DRB Project No: PR-2023-008274 Date: 9/13/2023 Agenda Item: #1 Zone Atlas Page: C-19

Legal Description: Lots 10 and 11 BLOCK 9, UNIT 3, NORTH ALBUQUERQUE ACRES

Application For: SD-2023-00151-PRELIMINARY PLAT (DHO)

DRB Project Number: 2023-008274
7310 and 7330 Carmel

DRAWING NAME
GRADING & DRAINAGE PLAN

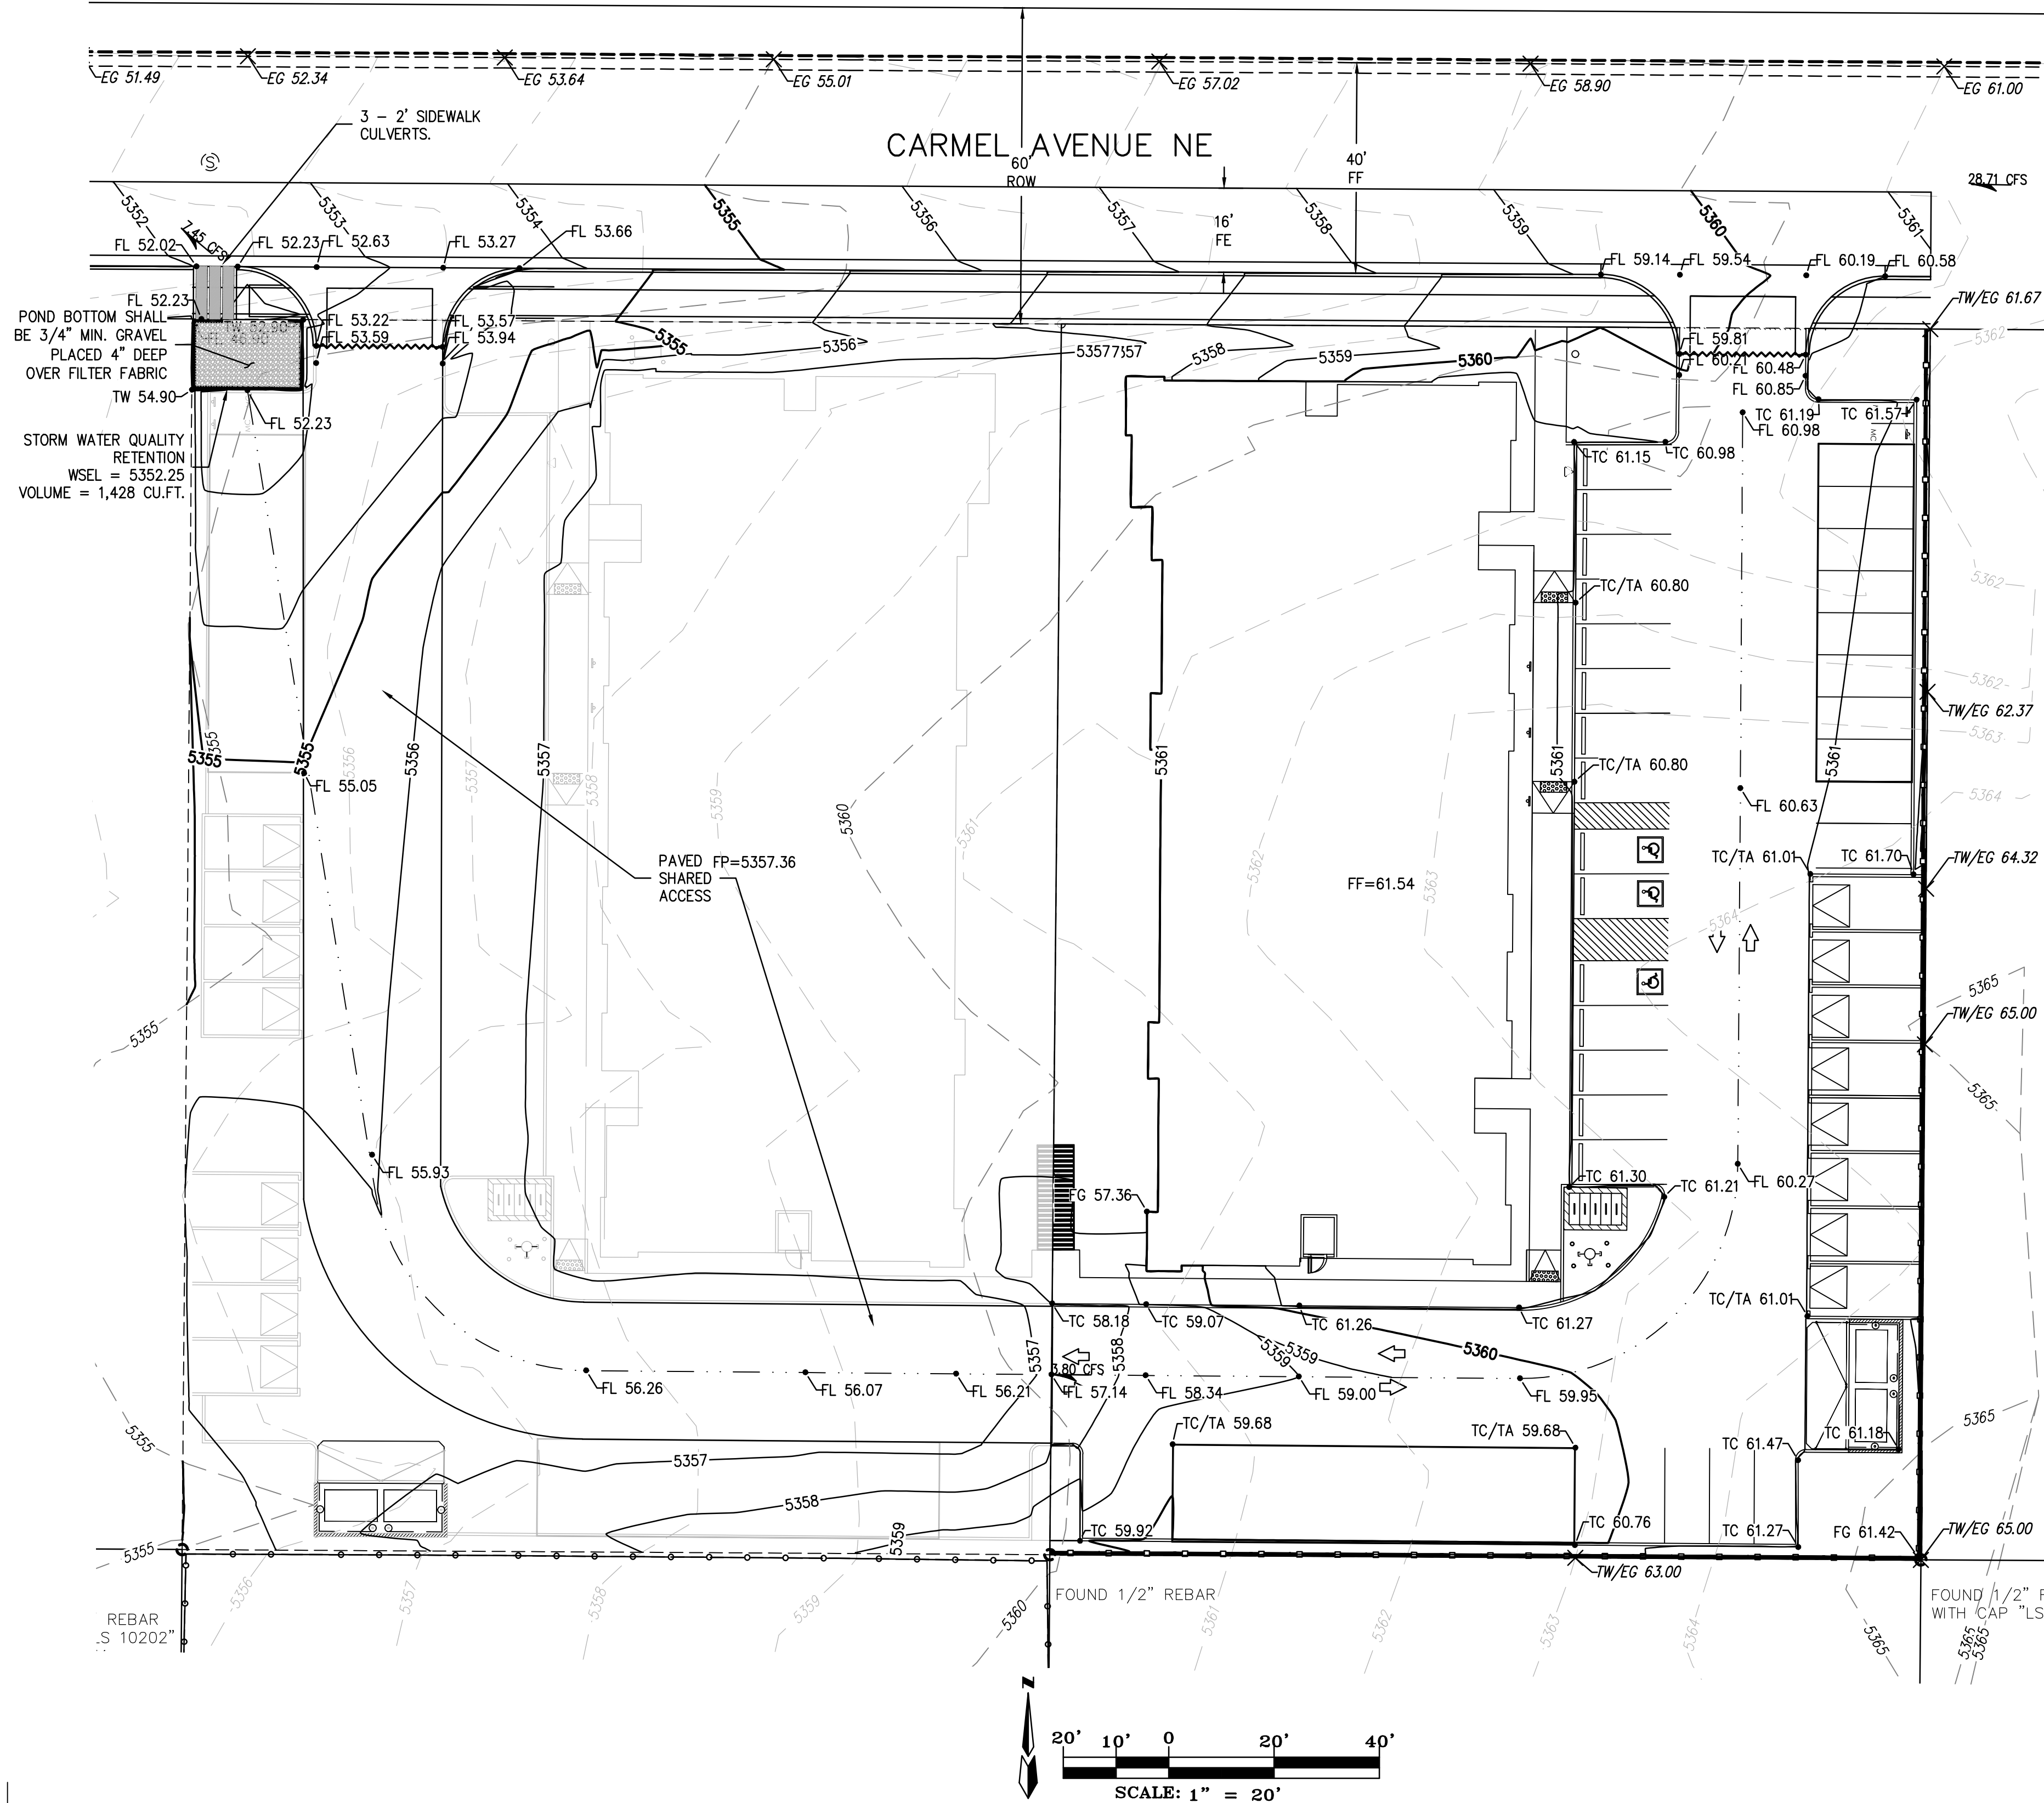
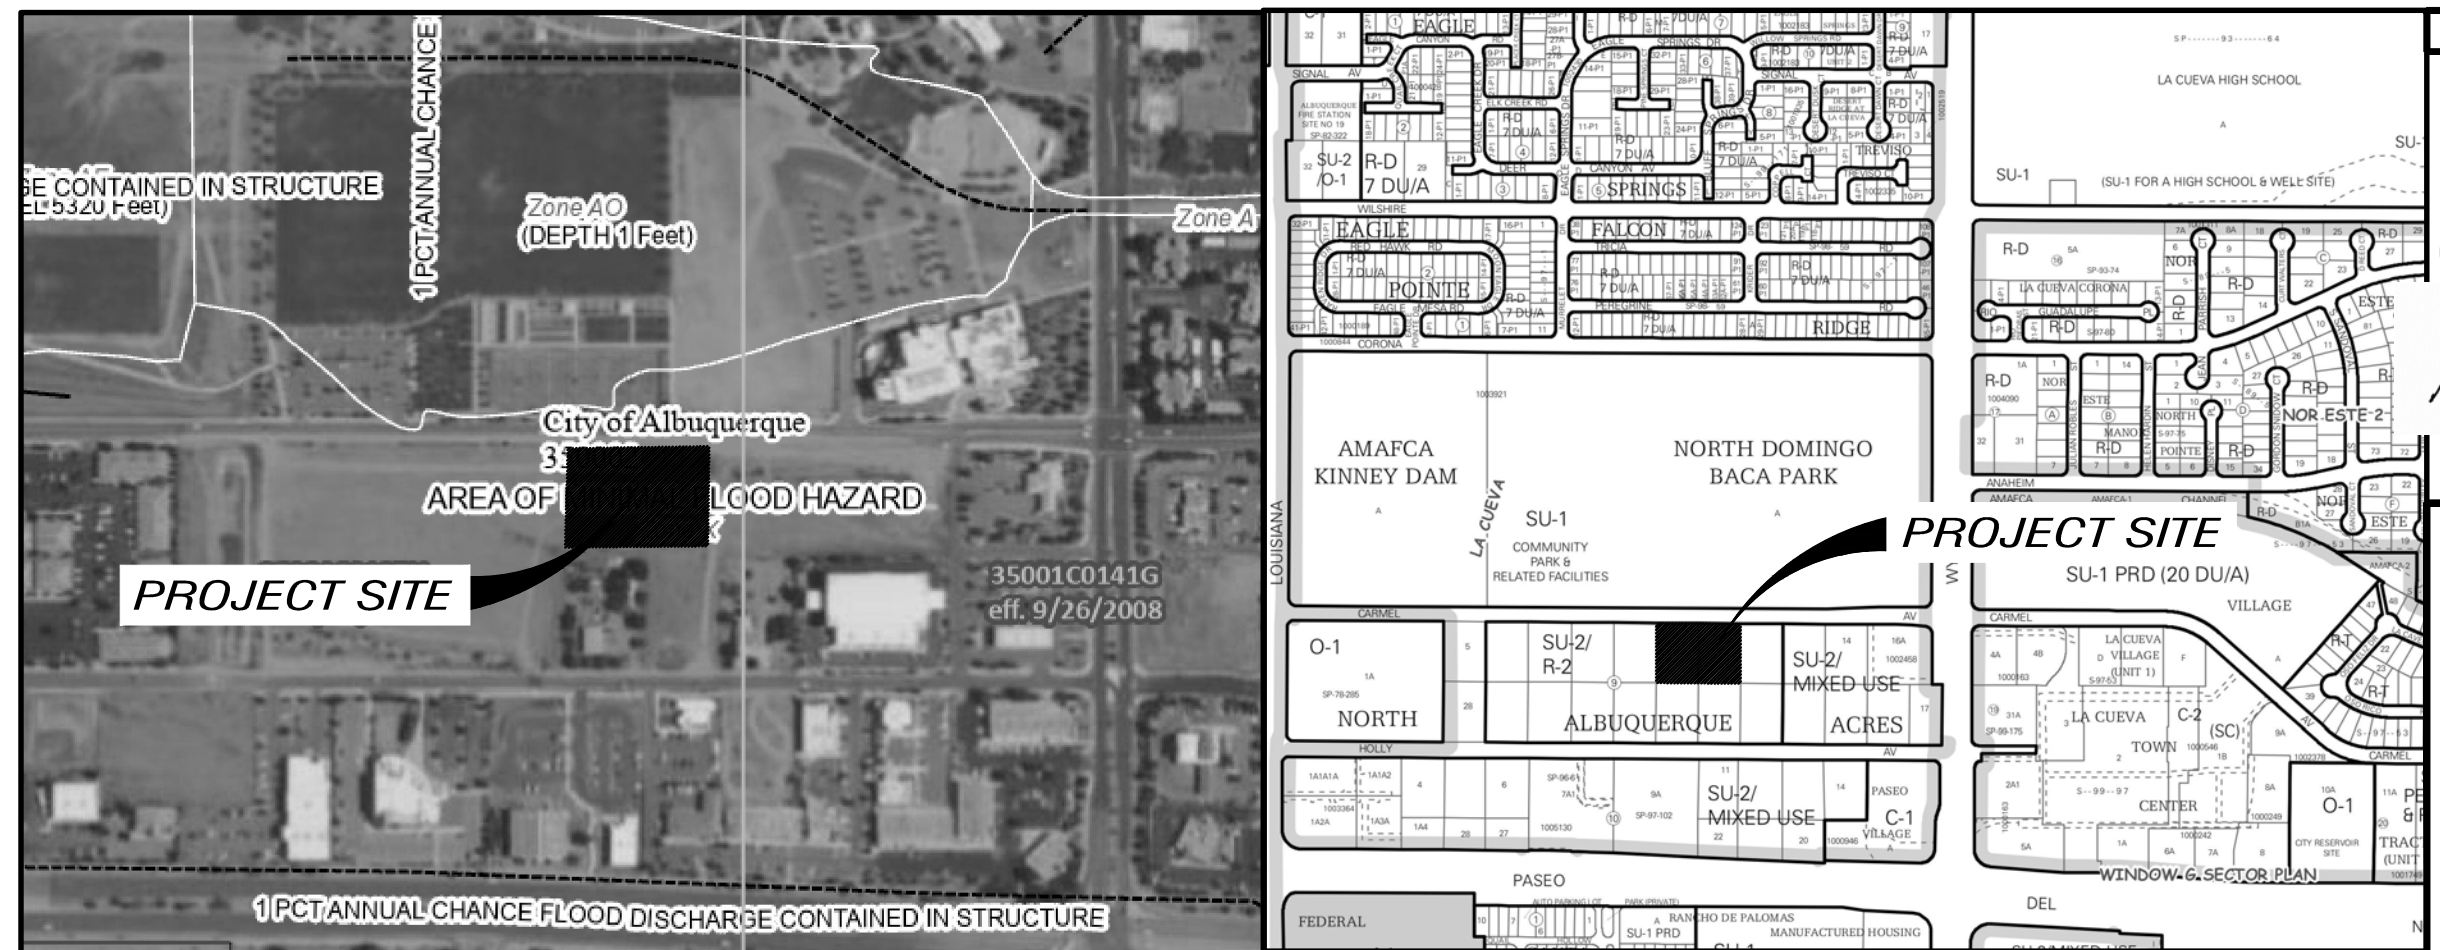
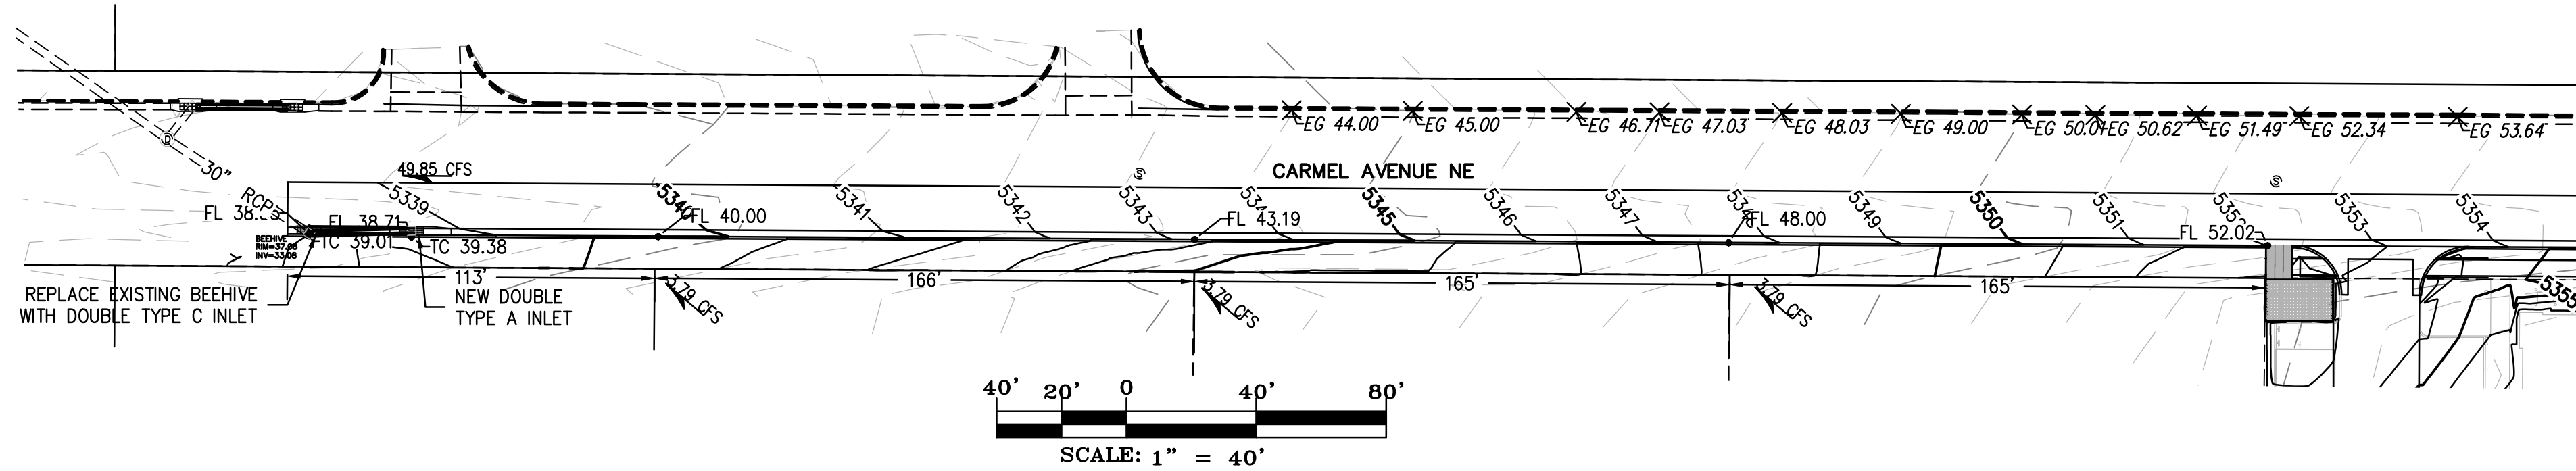
1. Carmel is a Major Collector and requires 6' sidewalk and a 5-6' Landscape buffer. Your plan and infrastructure list only list a 5' sidewalk. Please make these adjustments.
